**Item No.**                      **Report of the Head of Development Management and Building Control**

**Address:**                      77-79 HIGH STREET RUISLIP

**Development:**                Construction of 4 dwellings with associated stair and lift enclosure and landscaping.

**LBH Ref Nos:**                52931/APP/2023/3536

1 Second Floor Concept
1 : 100

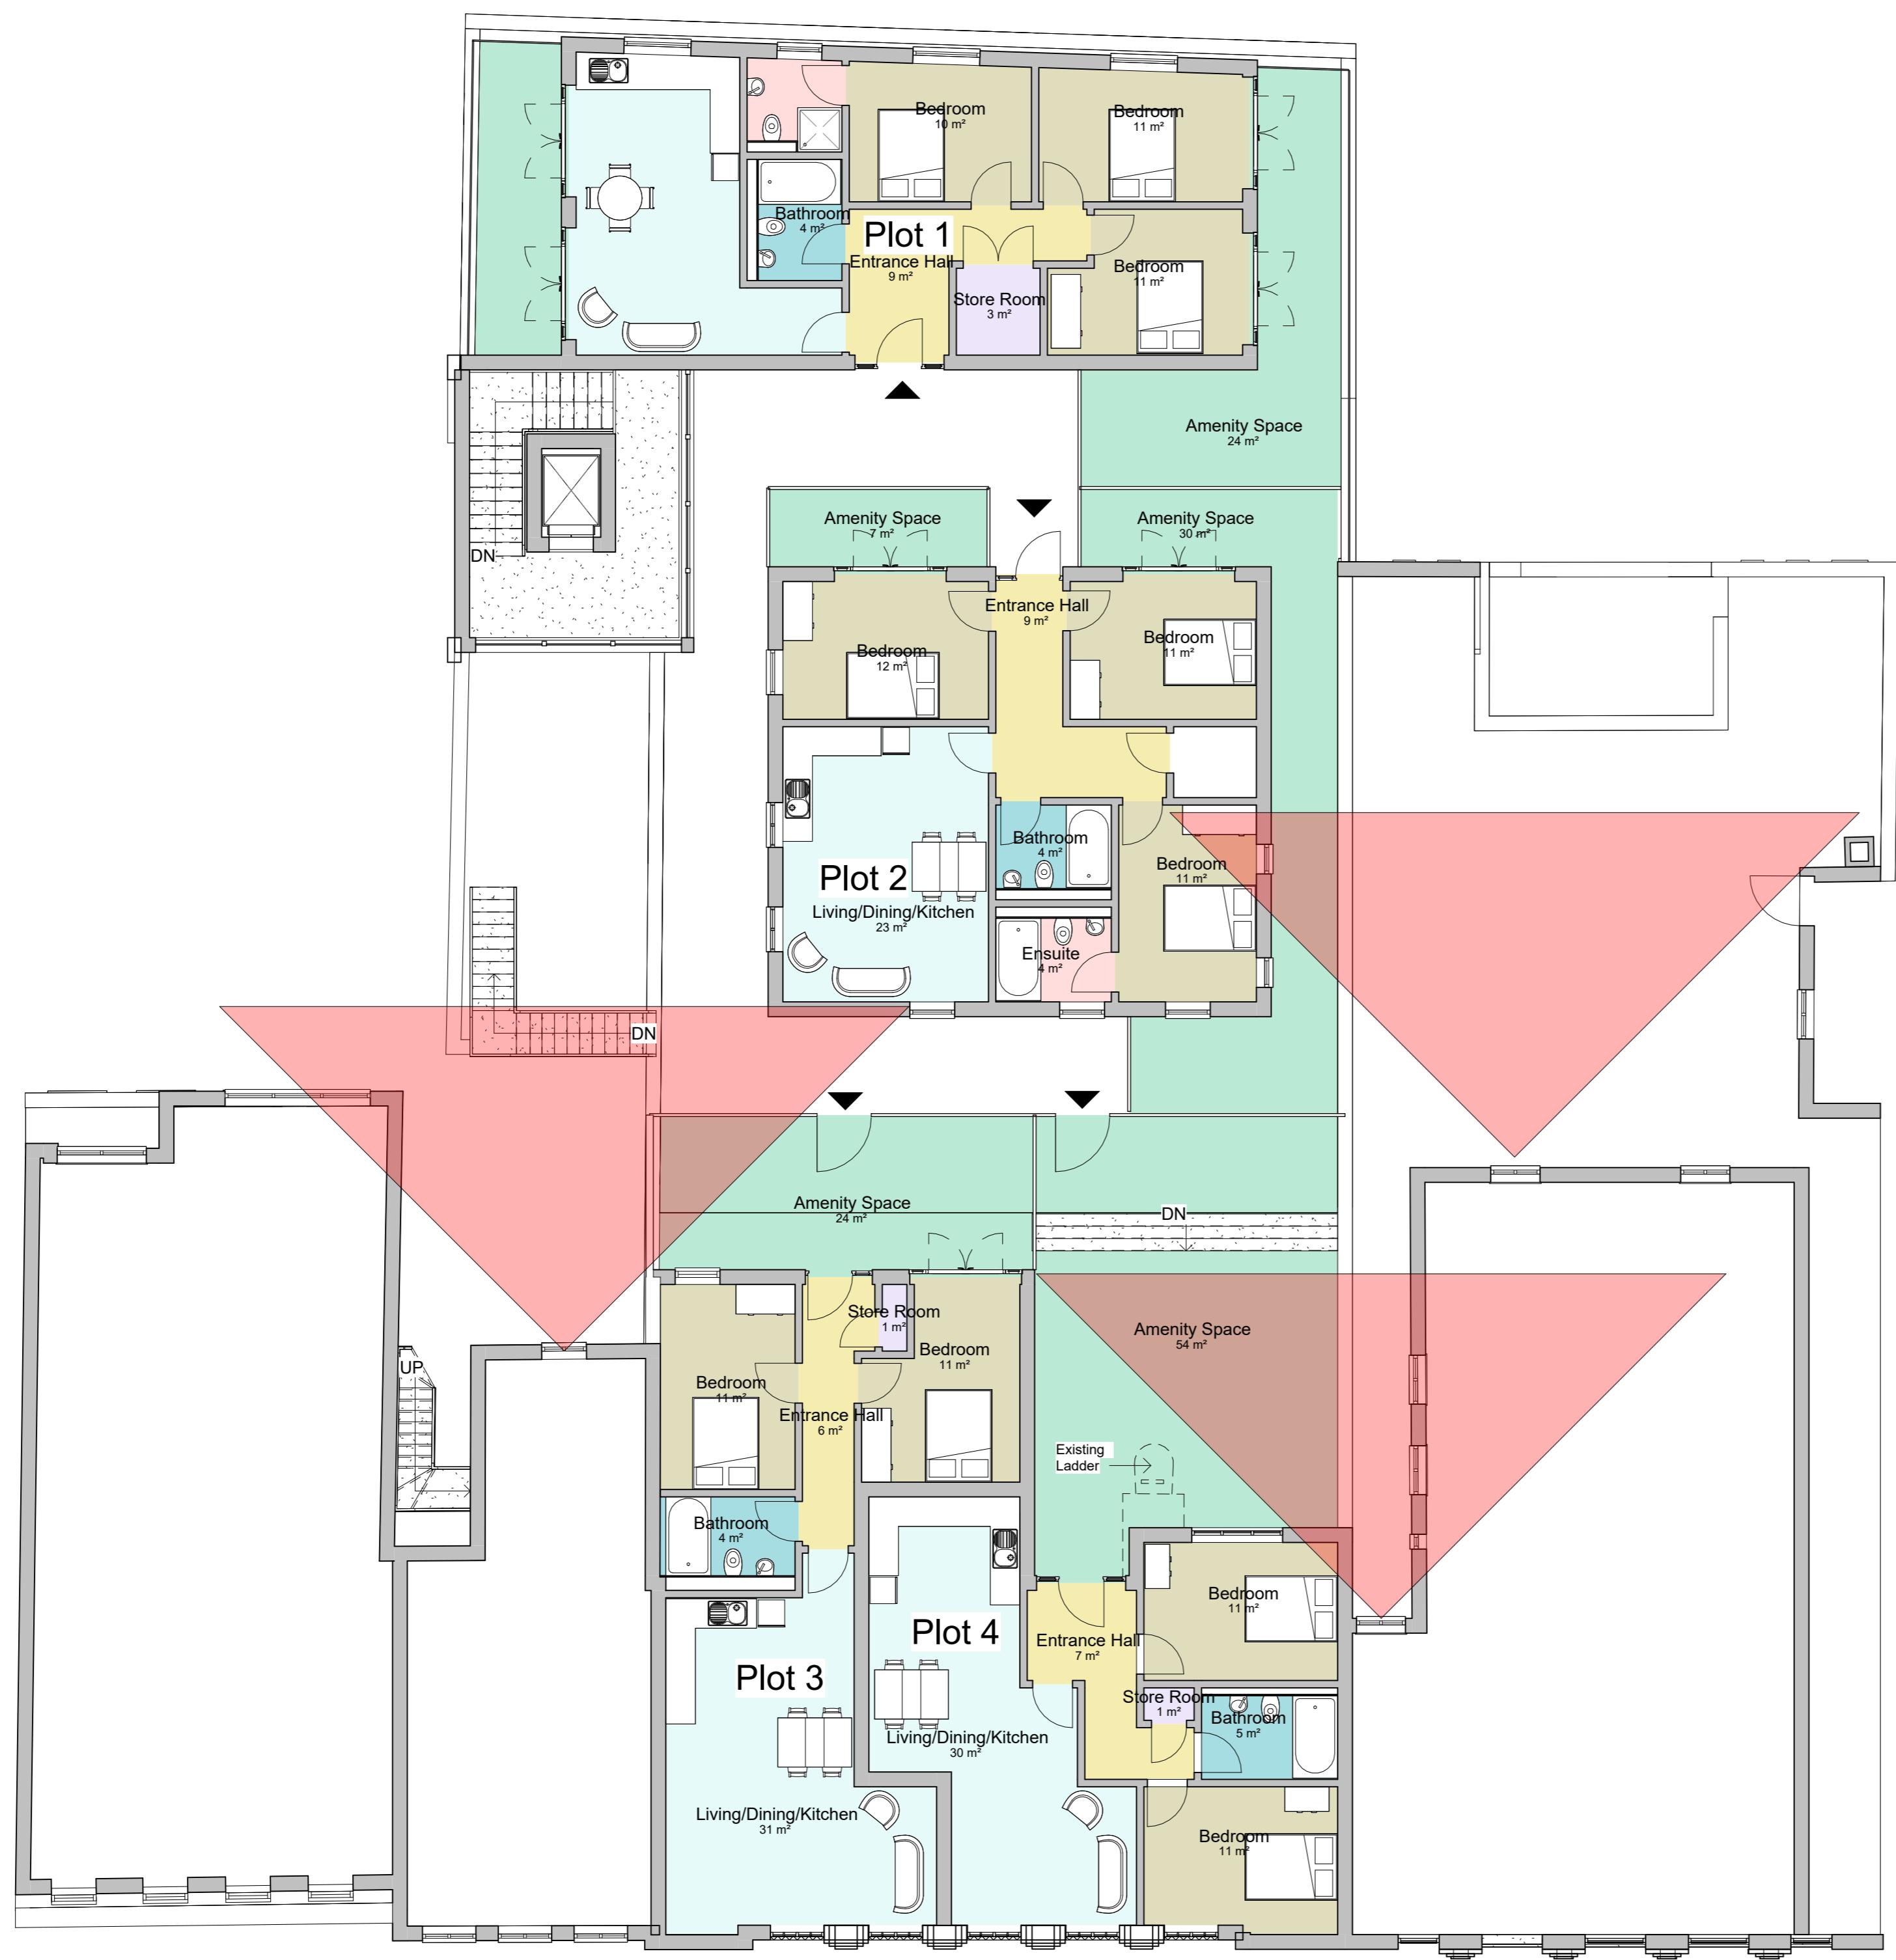
Due to the juxtaposition of the unit 2 and its proximity, the development would breach the 45 degree line of sight measured from the rear windows of both adjoining neighbouring buildings at Nos. 73A and Flats 1-3 81-83 High Street. There are also two side windows in the neighbouring building Flats 1-3 81-83 High Street that have not been accounted for in the plans, which face directly towards the side elevation of Unit 4 and its amenity area. As a result, levels of privacy for both the neighbour and future occupiers would be severely affected. The development would negatively affect the outlook of these neighbouring window and levels of sunlight/daylight provision.

Unit 1 would be located on the north-eastern edge of the building, which is noted to be 4 metres to the rear boundaries of Nos. 29-31 South Drive. There would be three primary windows facing towards the rear garden areas of these neighbouring dwellings. Whilst the separation distance between the development and the rear elevations measures 27metres, the neighbouring occupiers would experience an acute sense of visual intrusion and loss of privacy of their private amenity areas.

Proposed Ground Floor

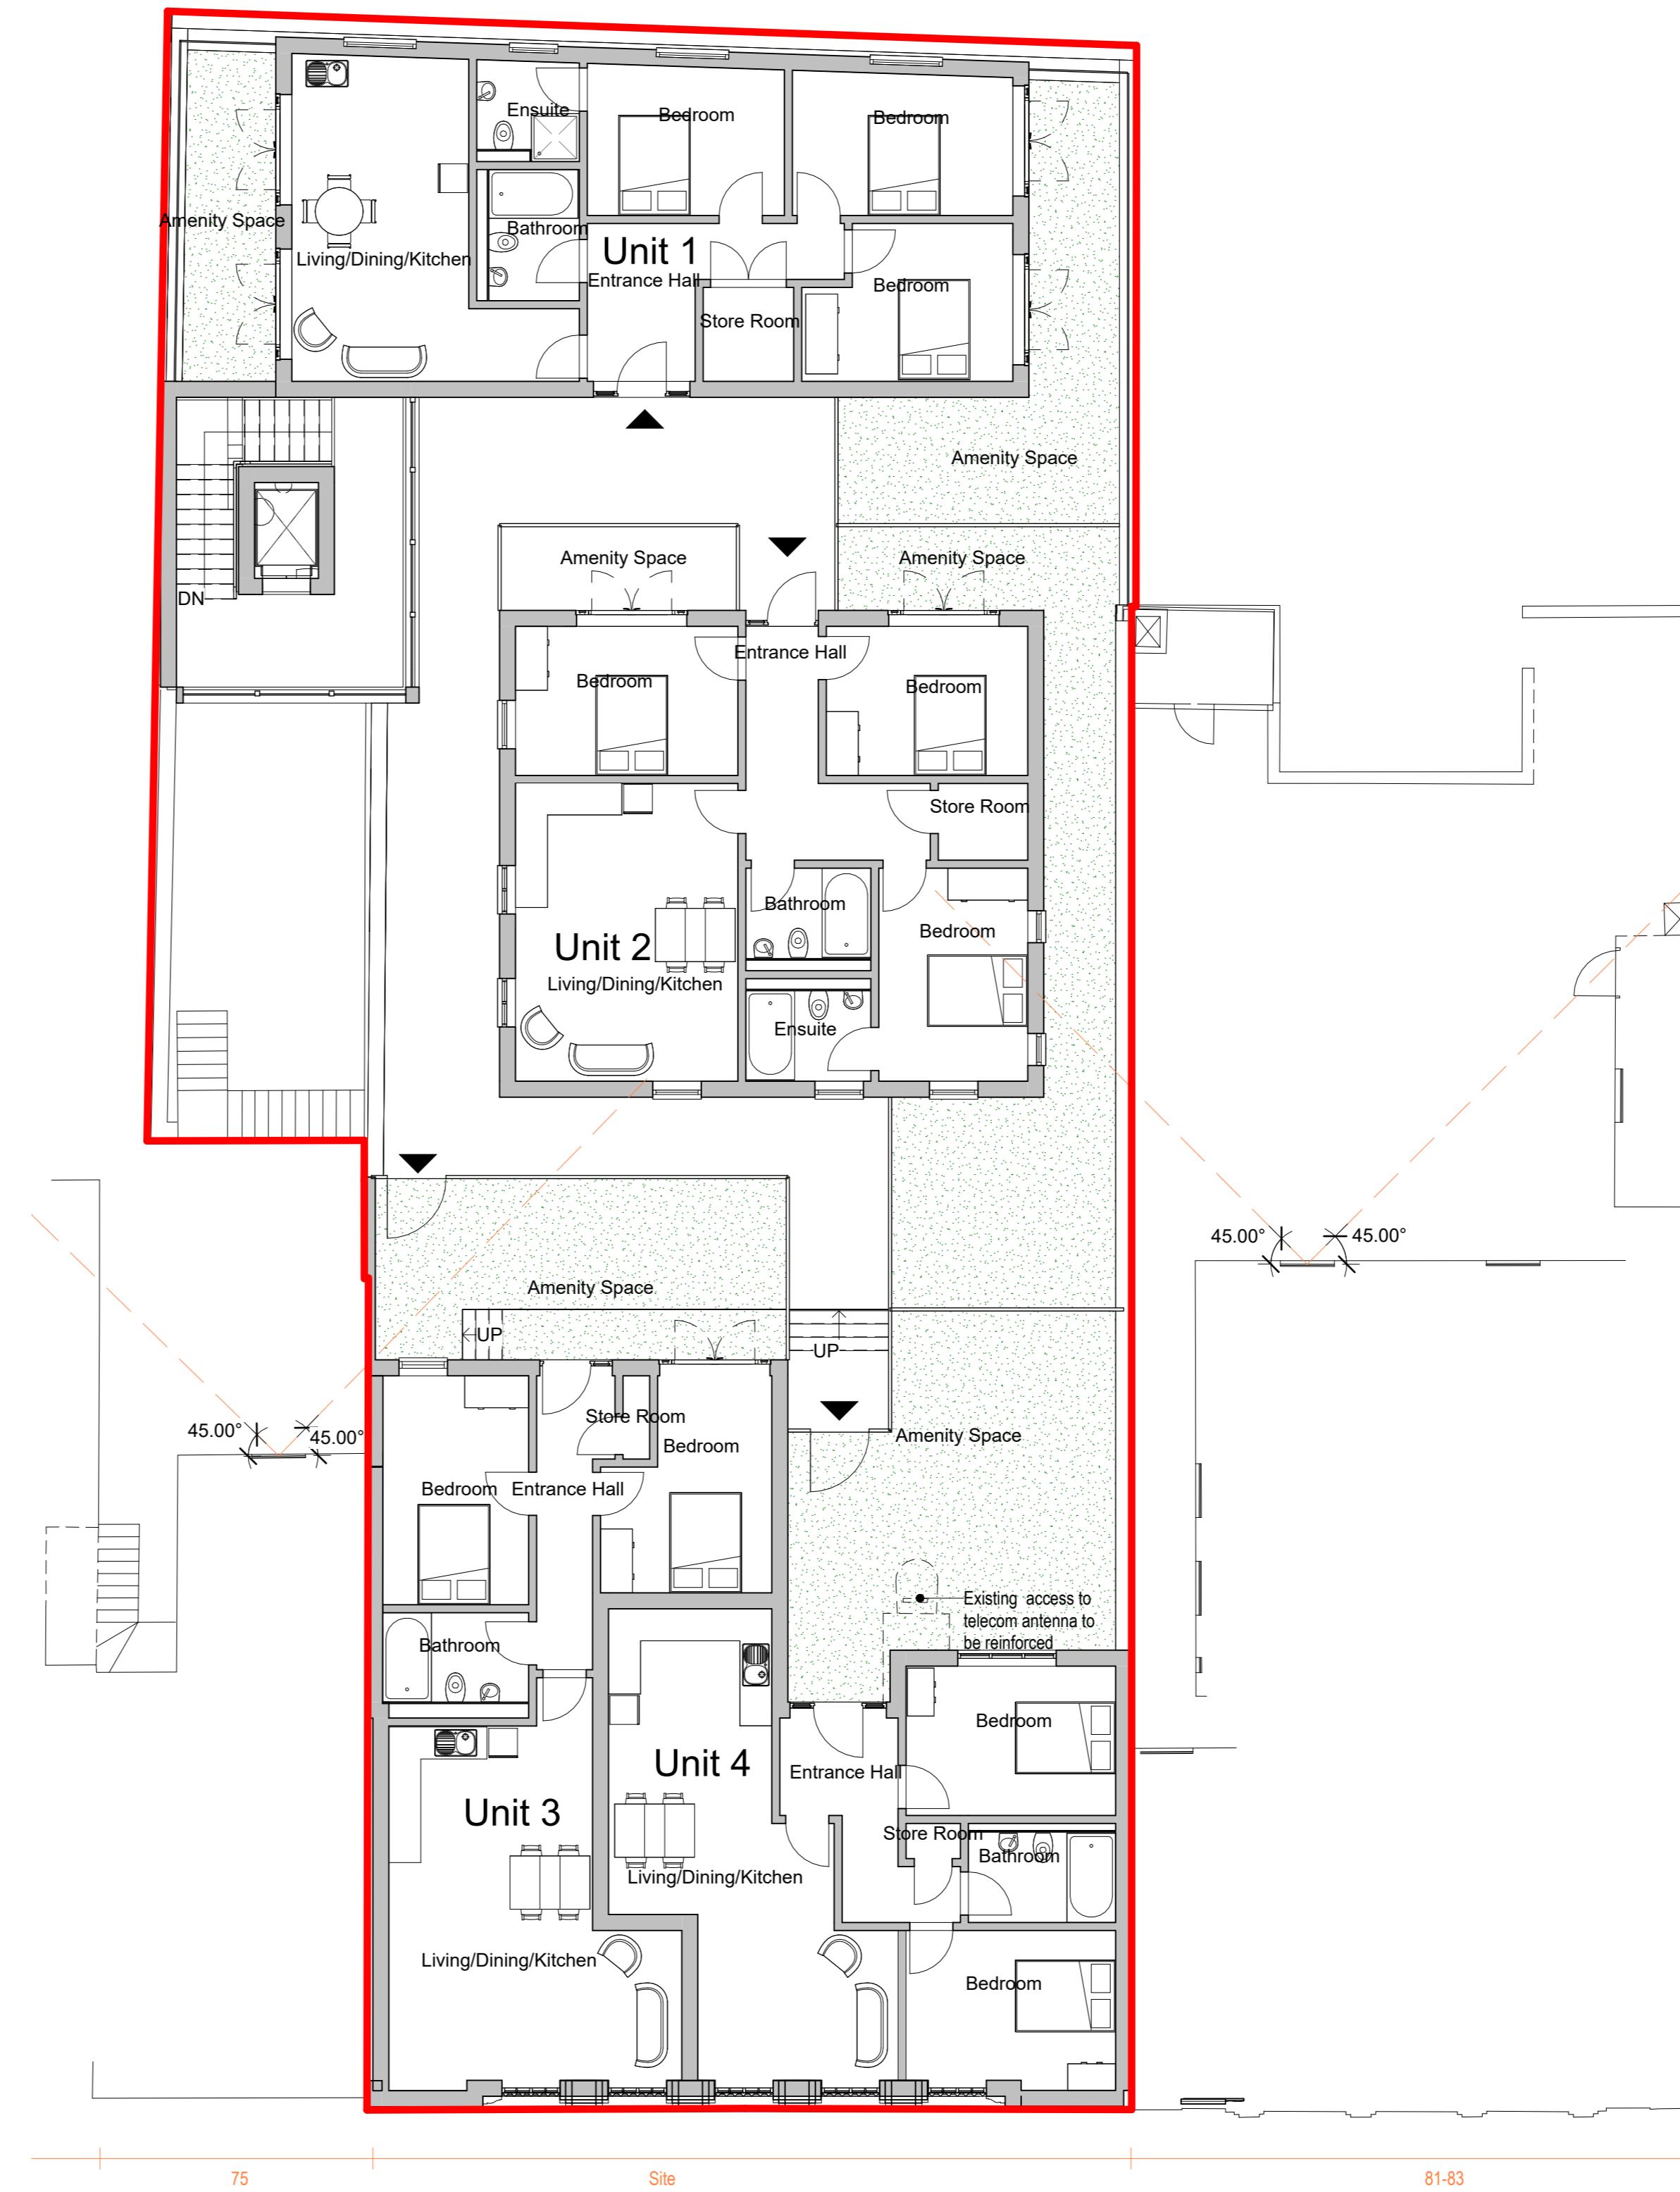
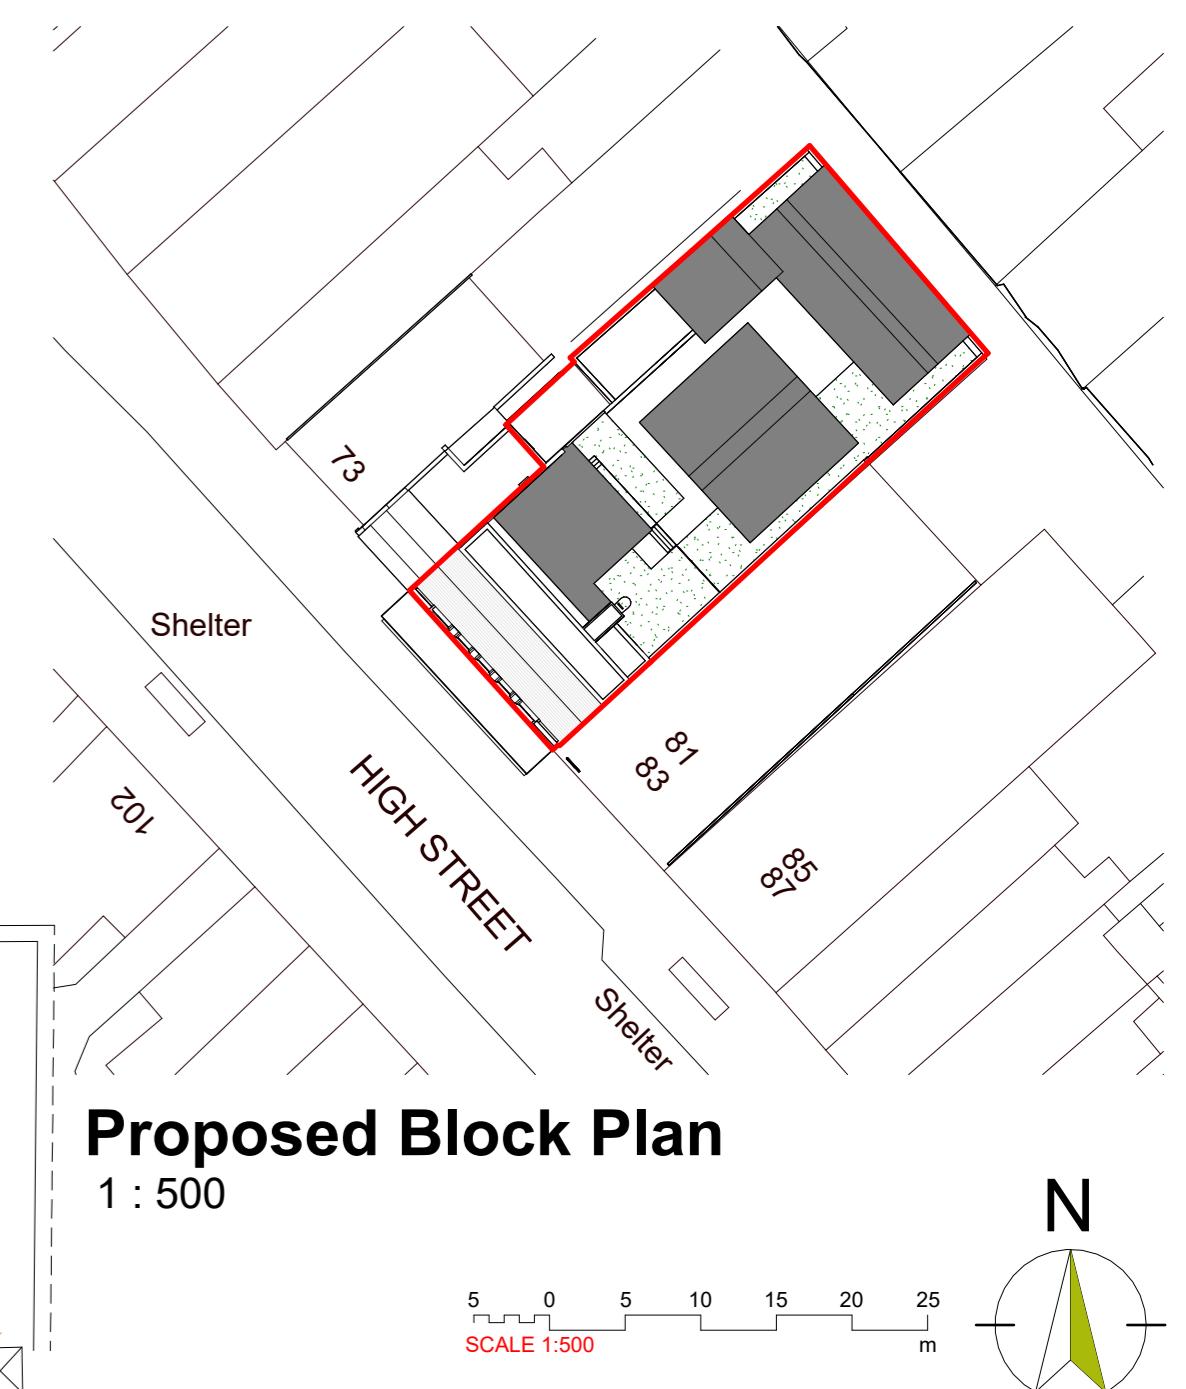
1. The approach and entry into units 3 & 4 on the Block Plan and Floor Plans Document are shown to be stepped.
2. The bathrooms shown within all four units do not meet the technical requirements of diagram 2.5 and 2.7 or otherwise meet the provisions set out in section 2.29 of Approved Document M, Volume 1 (2015 edition). Particular attention should be paid to the layout of the toilet pan, hand basin, and level access shower required to meet the above policy requirements.

3. Particular attention should be paid to the clear access zones and the spatial requirements within the bedrooms, bathrooms and kitchen areas. Floor plans at a scale of 1:100 should be submitted to show the clear access zones in context to typical furniture items within the said rooms.

4. The plans need to be amended to align with all other M4(2) technical specifications (as relevant), set out in Approved Document M to the Building Regulations (2015 edition).
